**Addendum No. 1**

RE: Contract ID C202966

WBS # 17BP.7.P.3

Bridges #11, 15, 59 & 61 on US-29, #152 on US-129 Business,  
and #63 on NC-62

SHEET NO. S-27
TOTAL SHEETS S-50

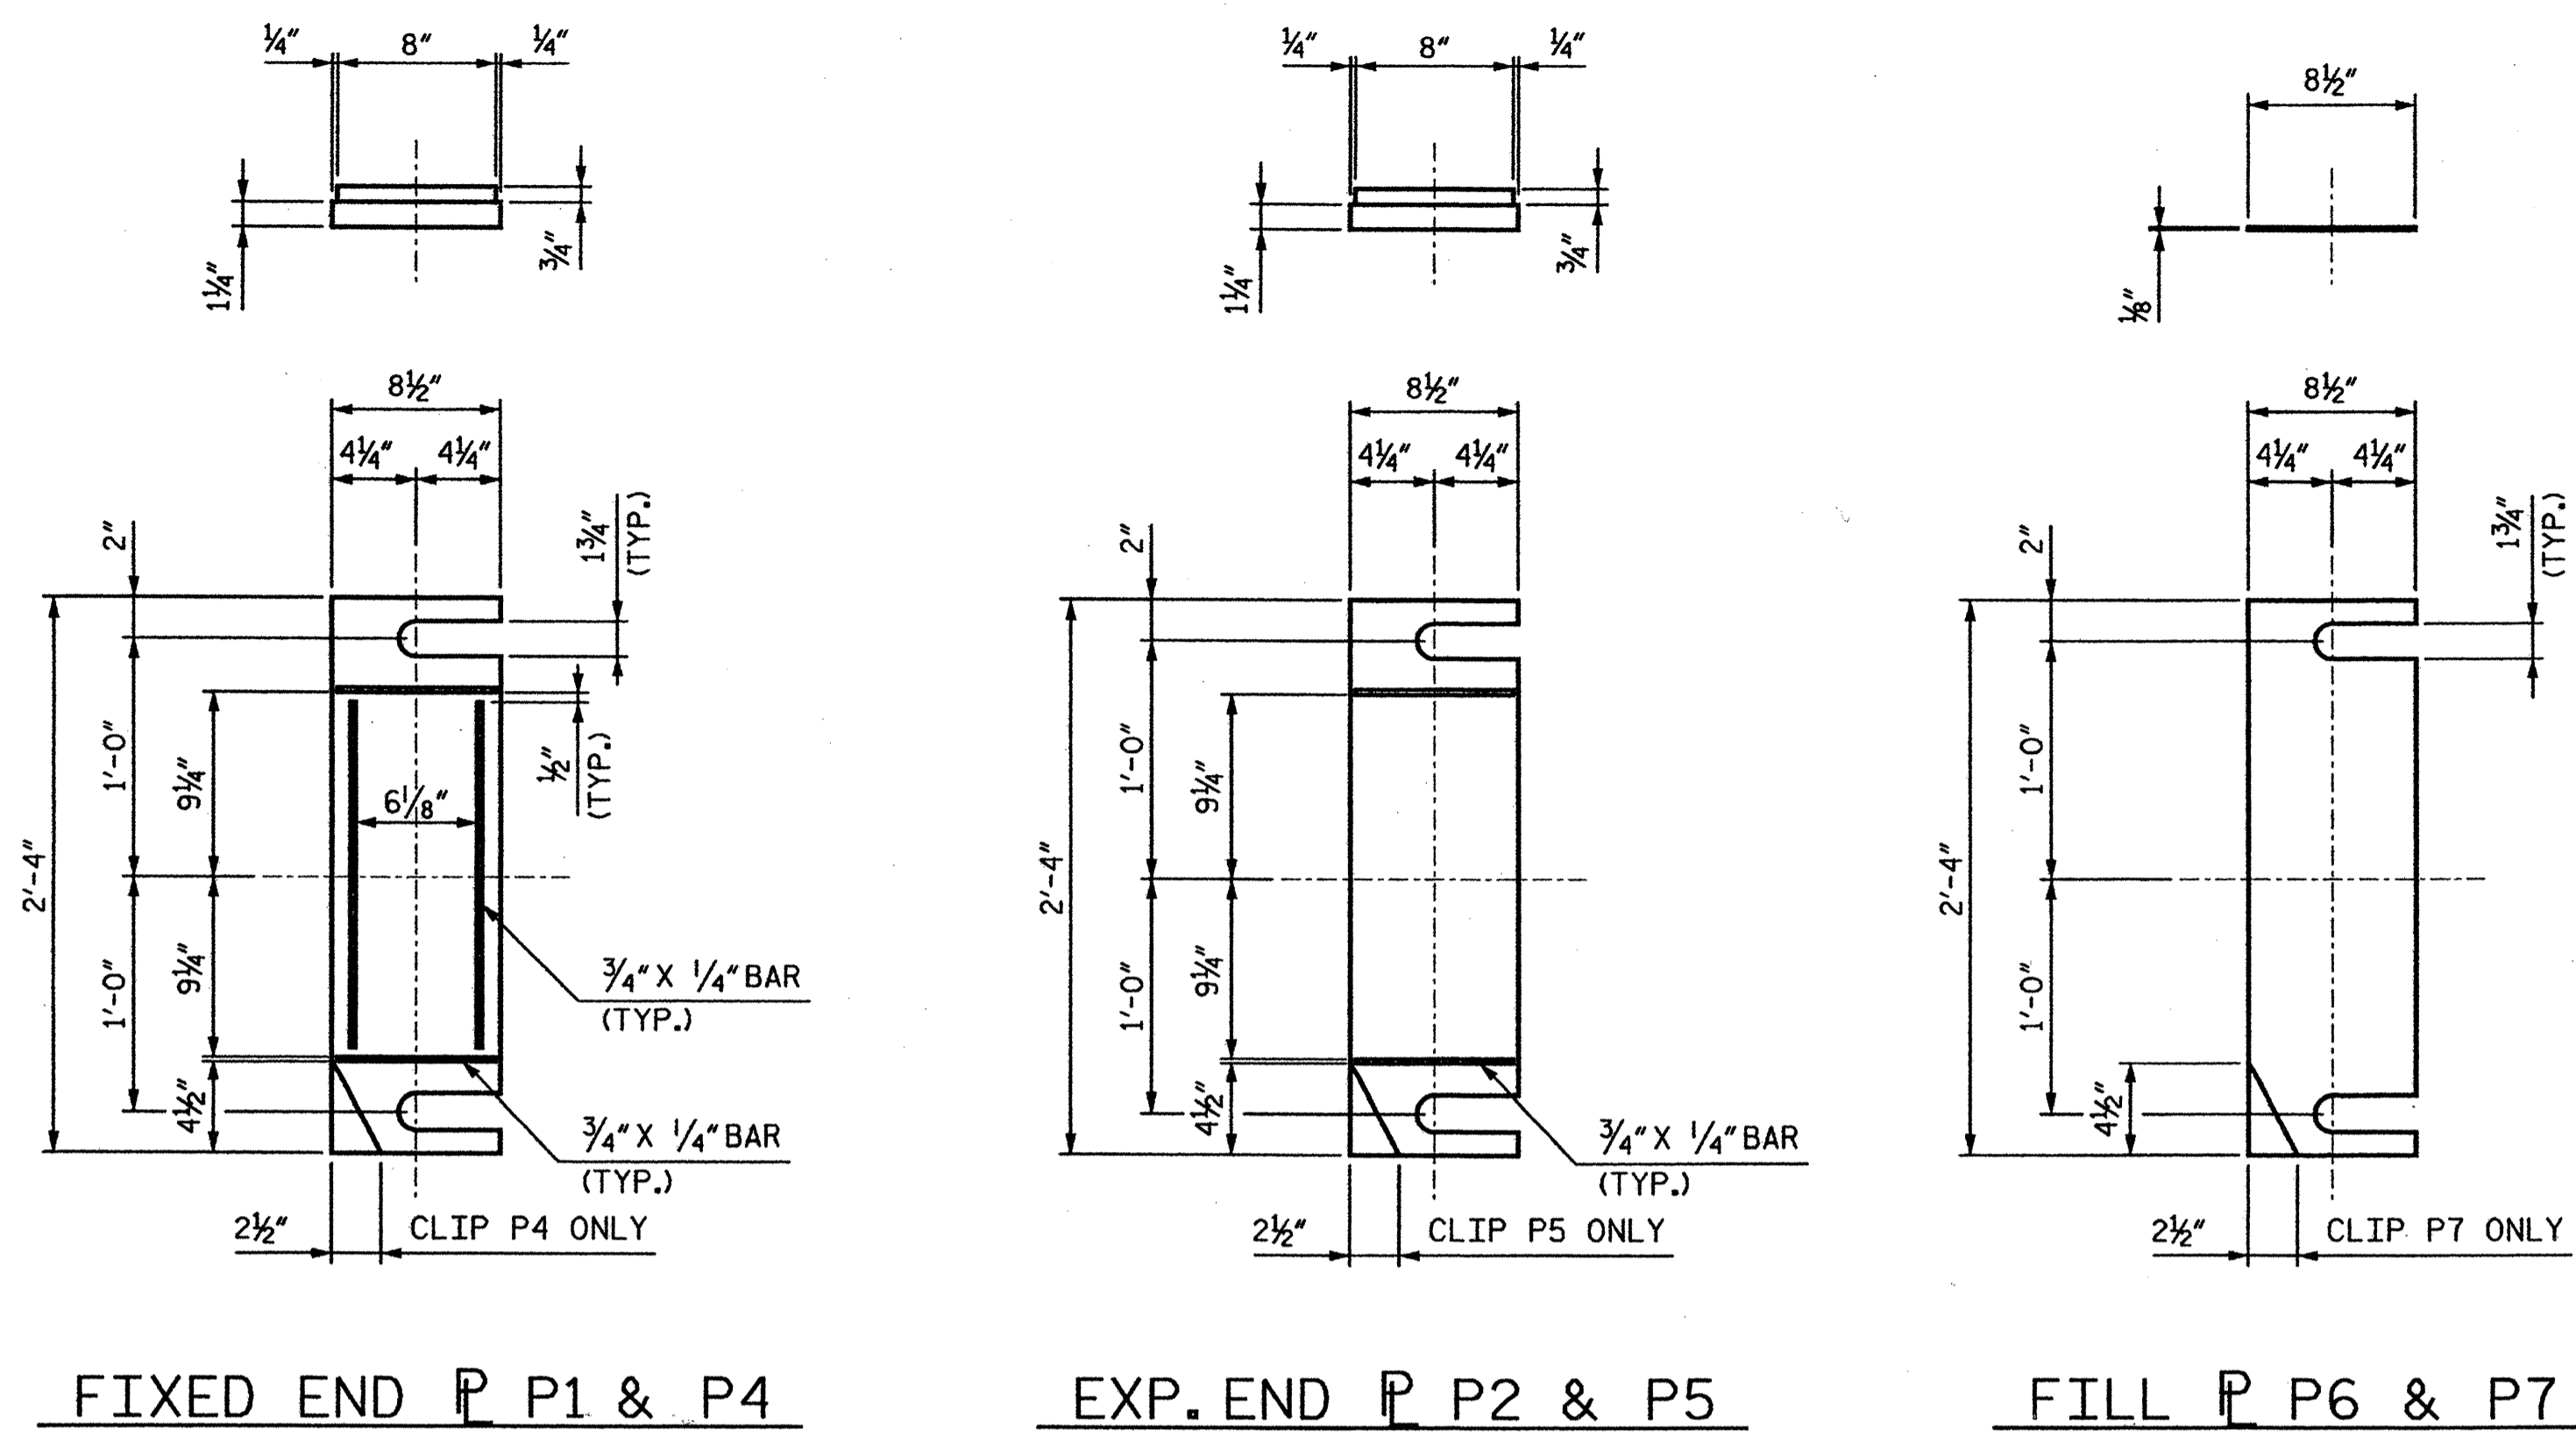
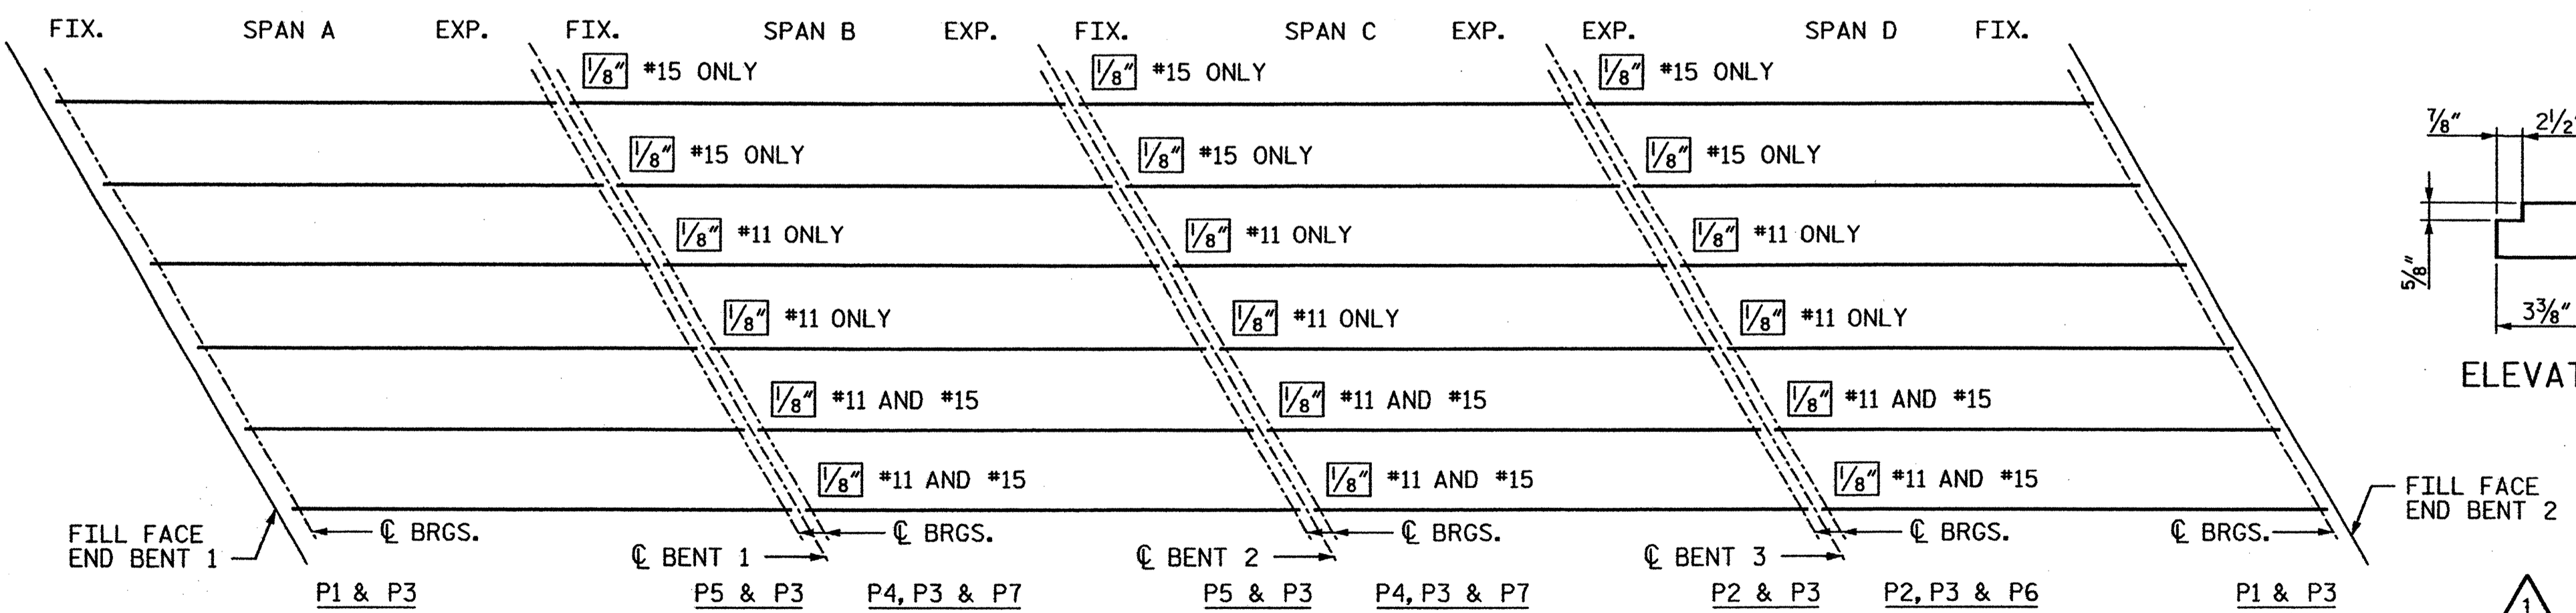
On Sheet No. S-27 notes have been revised or added as noted on the plans. Please void Sheet No. S-27 in your plans and staple the revised Sheet No. S-27 thereto.

SHEET NO. S-28
TOTAL SHEETS S-50

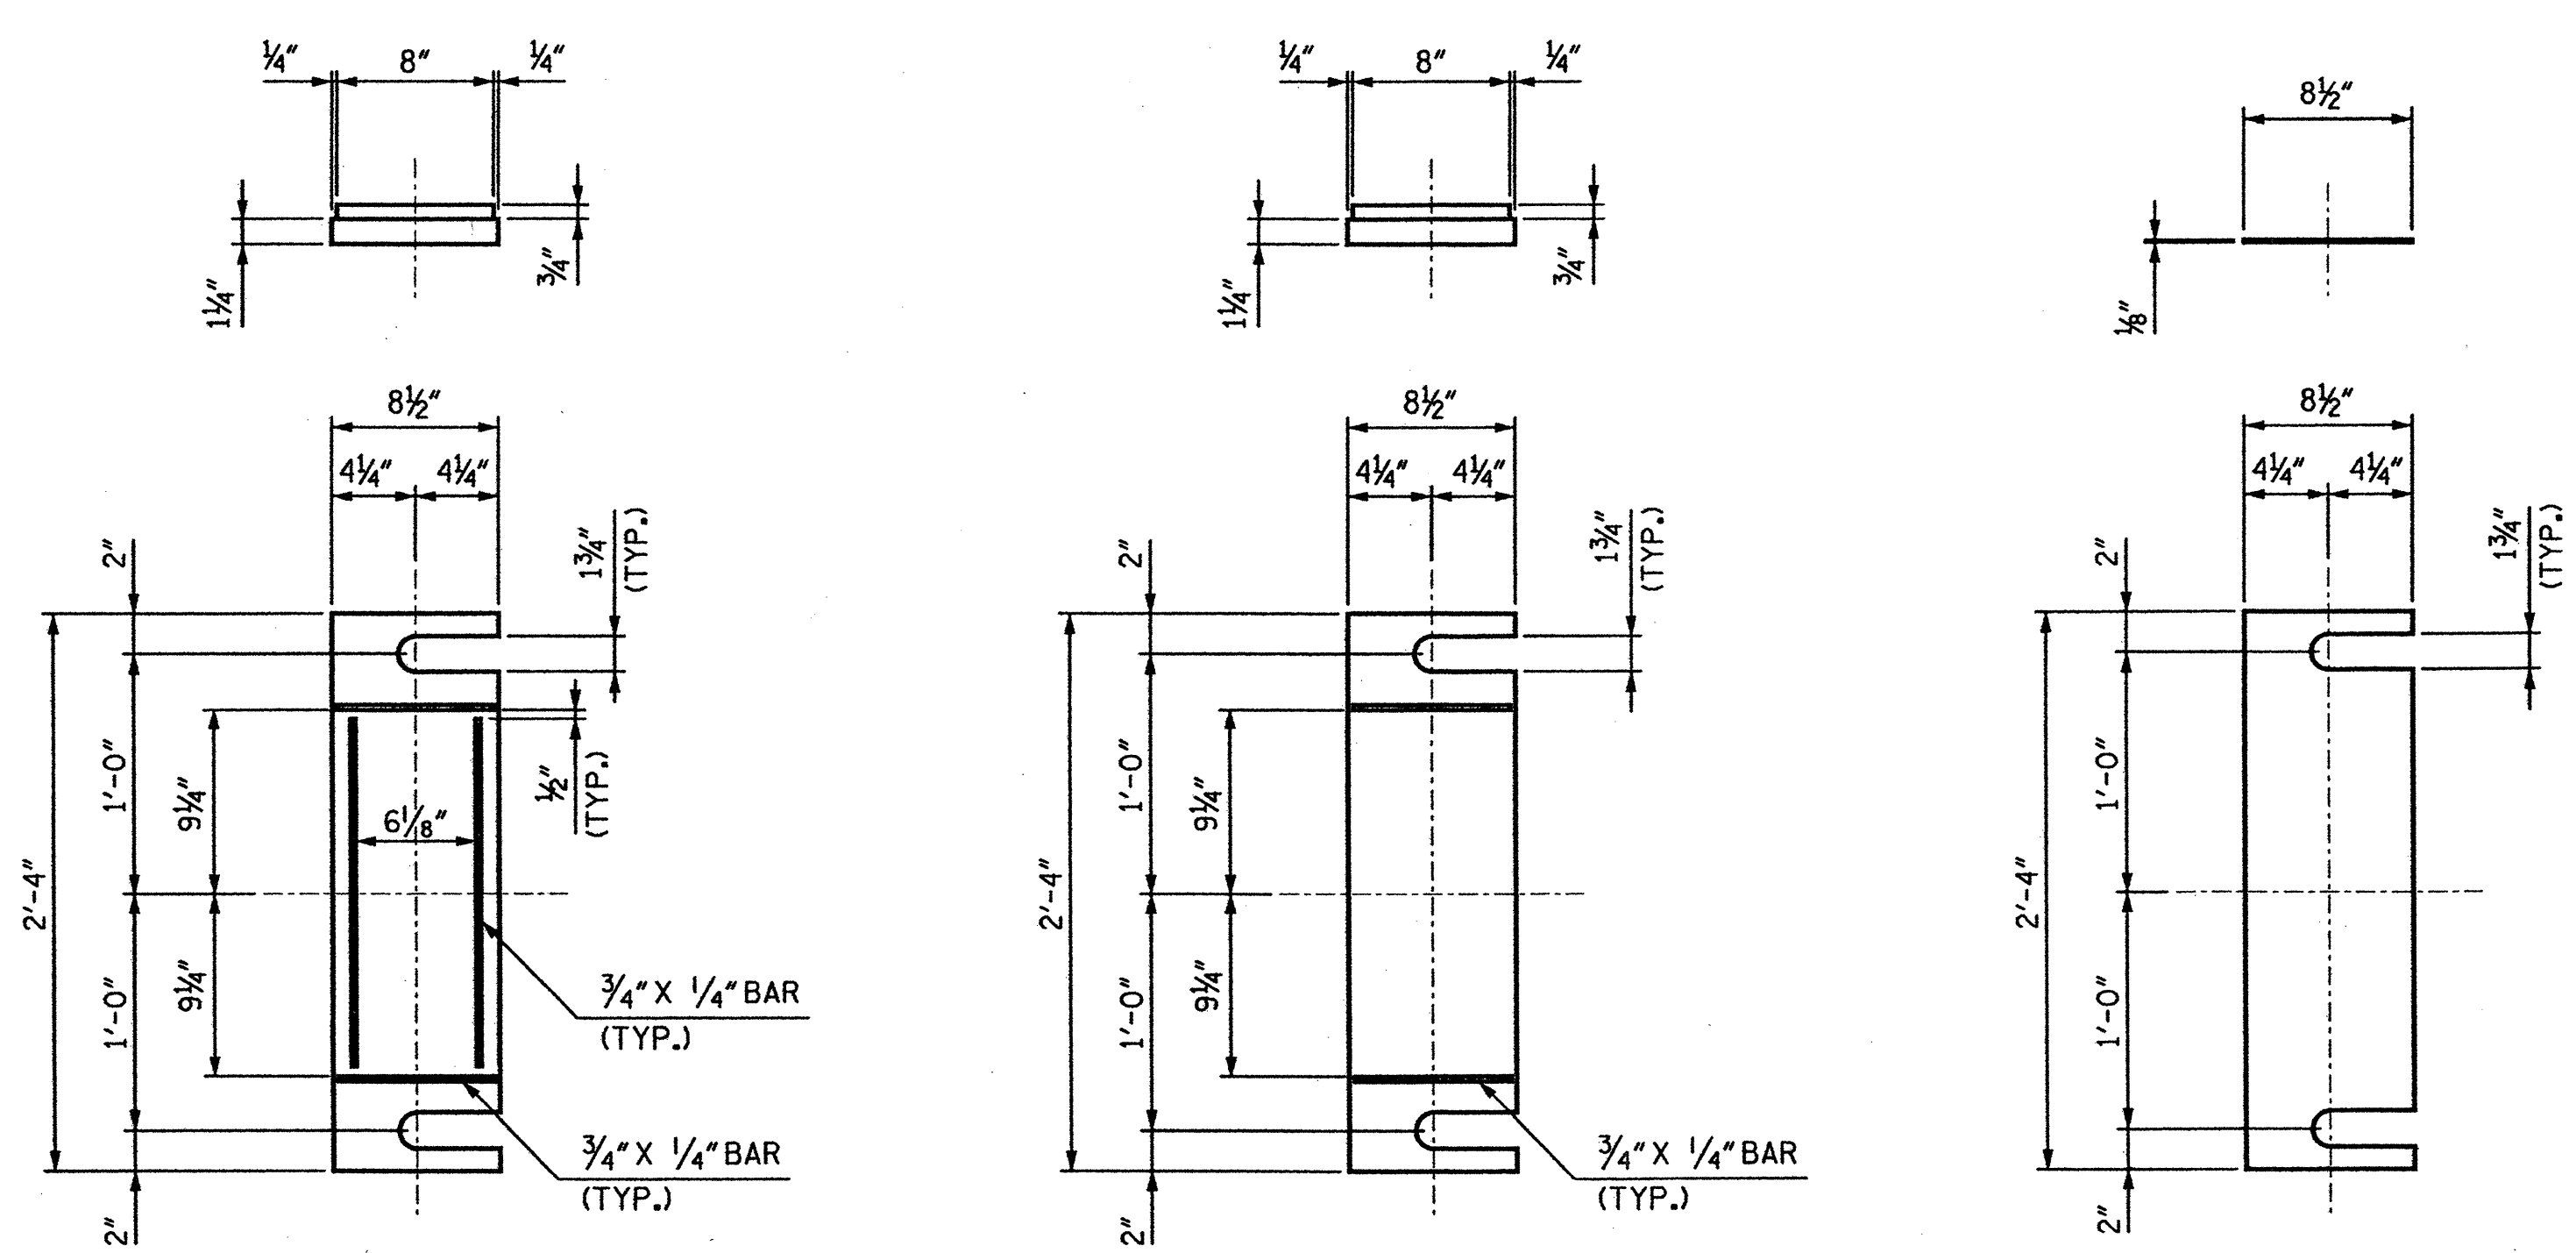
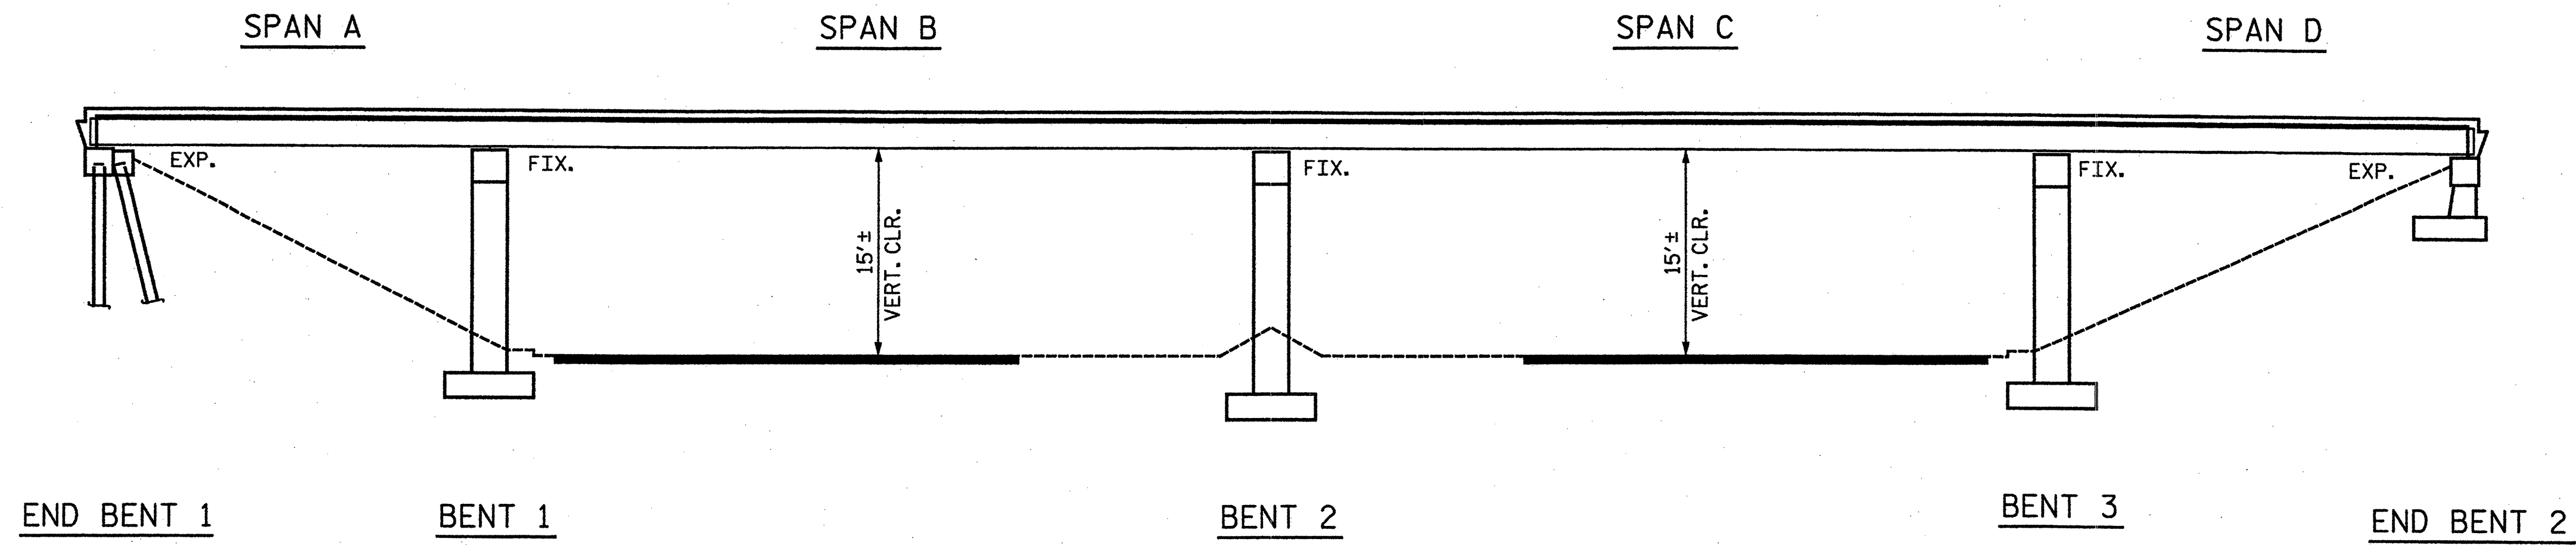
On Sheet No. S-28 notes have been revised or added as noted on the plans and the bearing replacement locations table was revised. Please void Sheet No. S-28 in your plans and staple the revised Sheet No. S-28 thereto.
